Walden Preserve 2 Filing No. 4A
Traffic Technical Memorandum
(LSC #184810)
September 7, 2018

Revise all text from
filing no. "4A" to filing
no. "4"

Add "PCD File No. SF-18-034"

RE: Walden Preserve 2 Filing No. 4A
El Paso County, CO
Traffic Technical Memorandum
LSC #184810

RURAL LOCAL-PAVED ROAD (PUBLIC)
(PINEHURST CIRCLE &, DEBOODT CT)
TYPICAL SECTION (A)
SCALE: 1"=5'

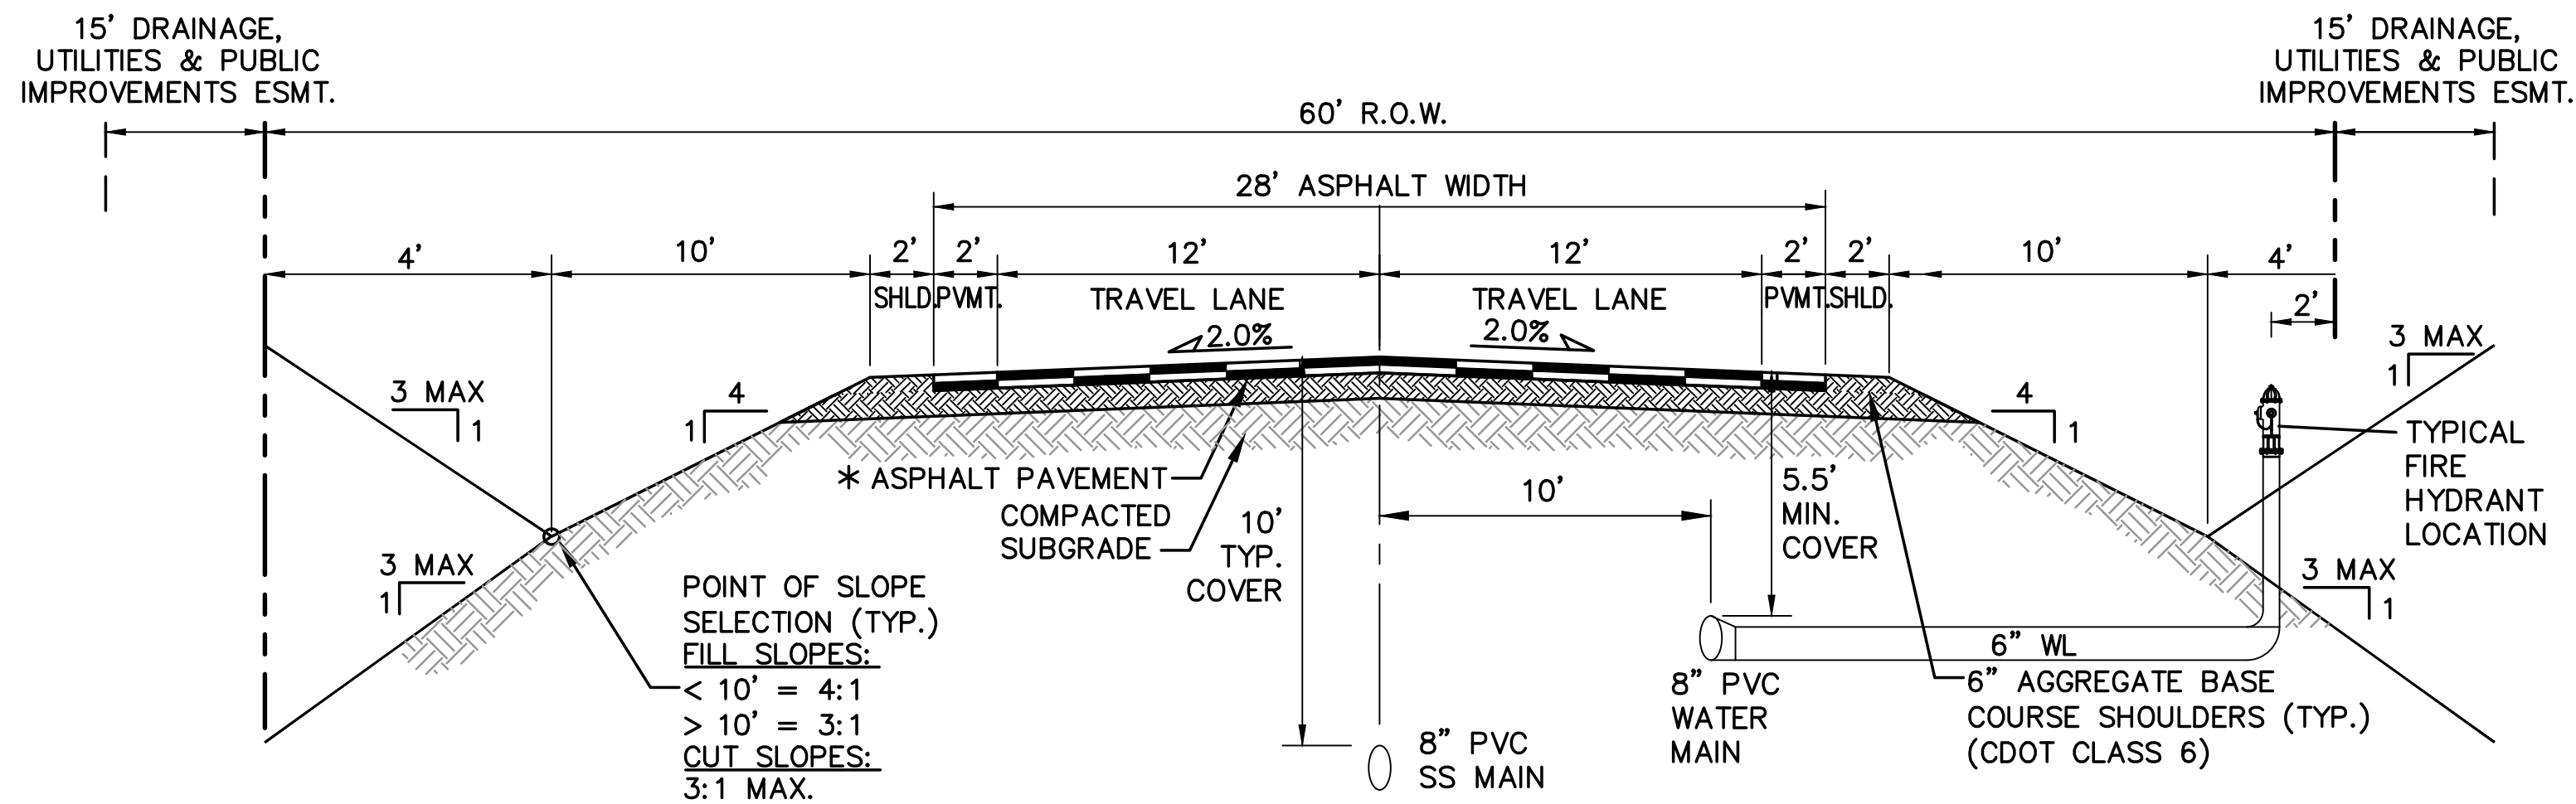
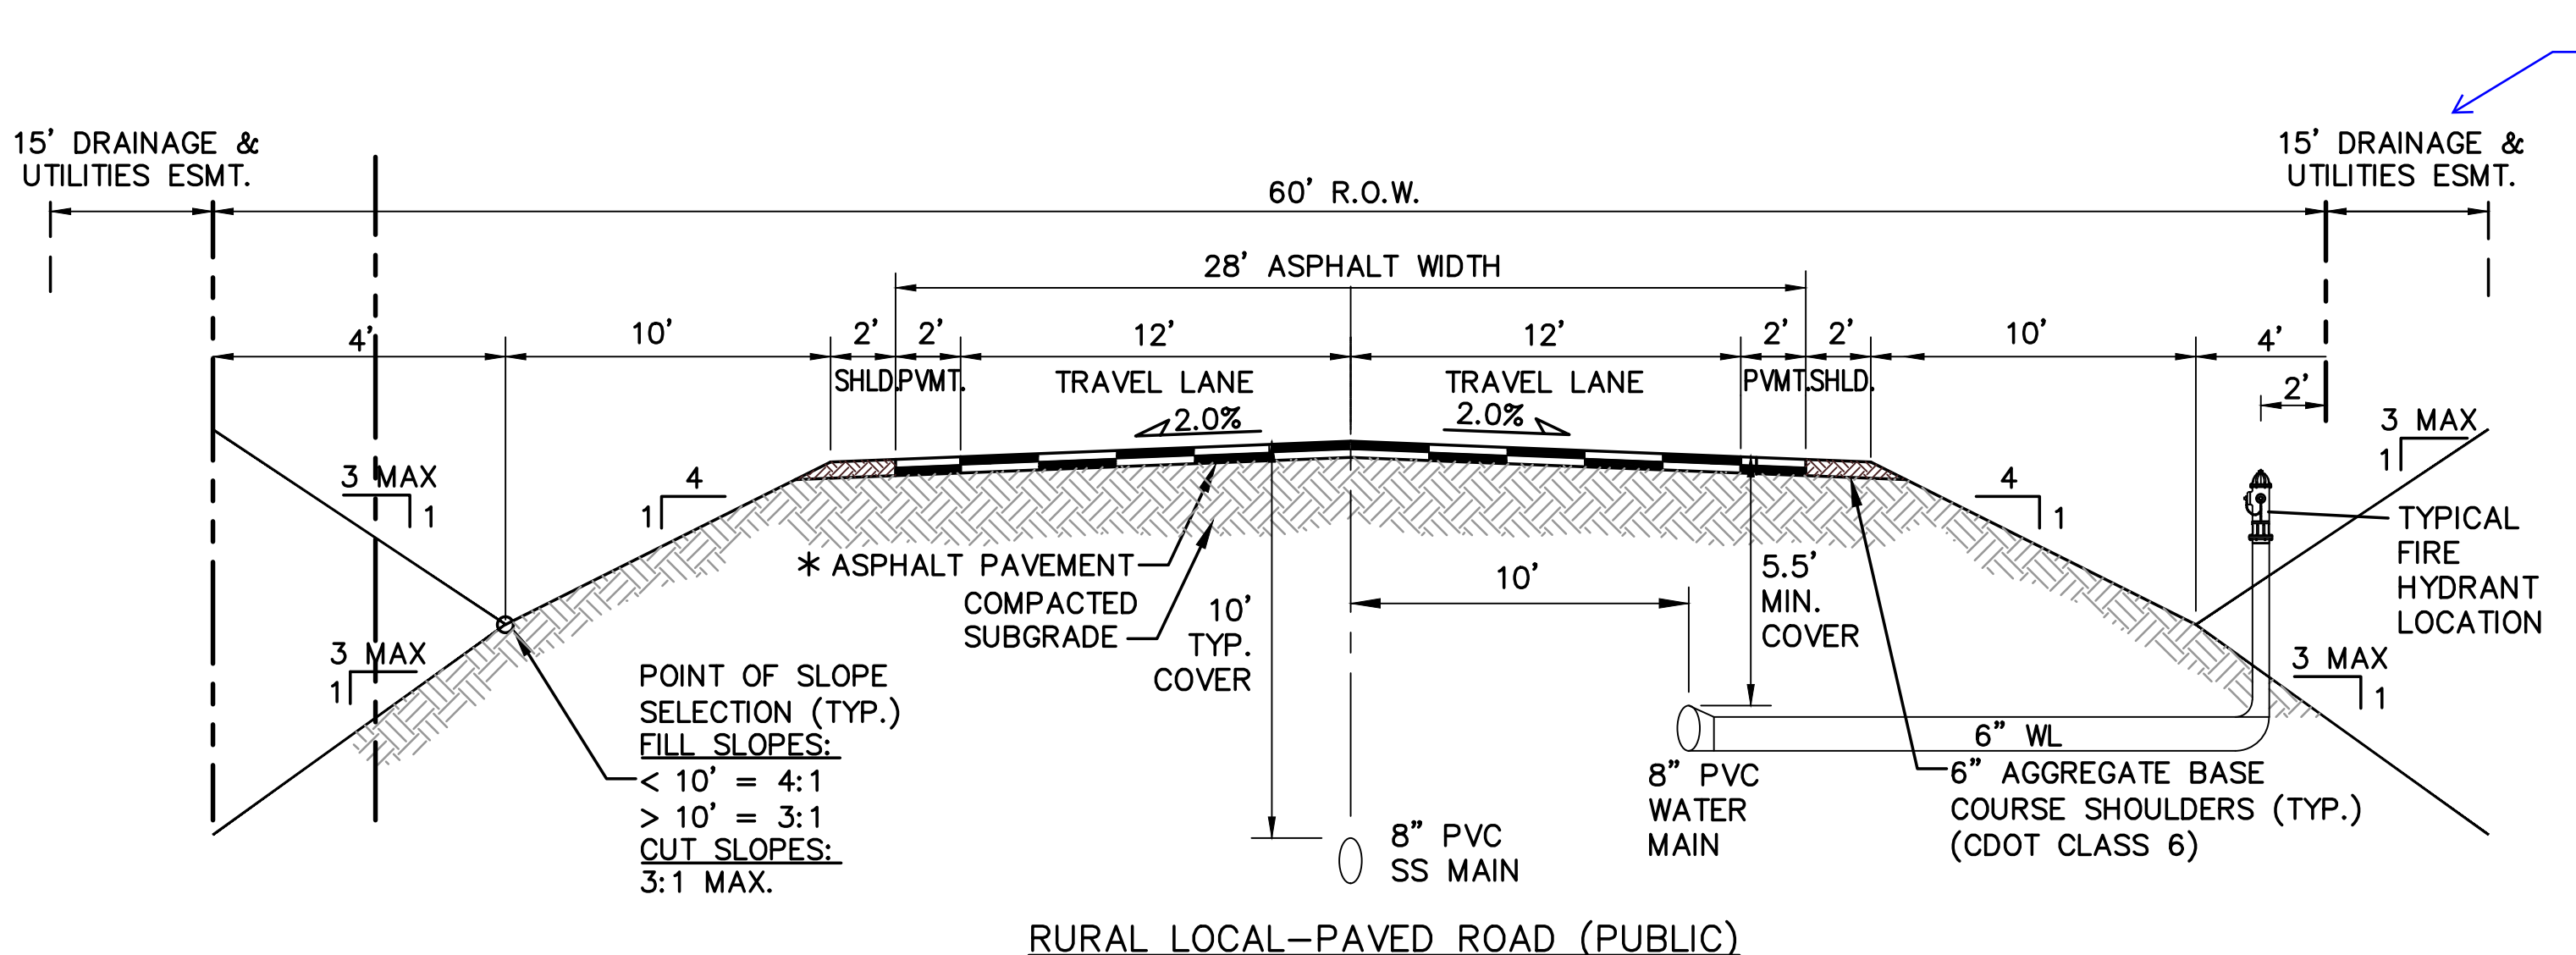
This contradicts the final plat note which states road impact fee to be paid in full. Verify with the developer and revise either the TIS or the Plat to match.
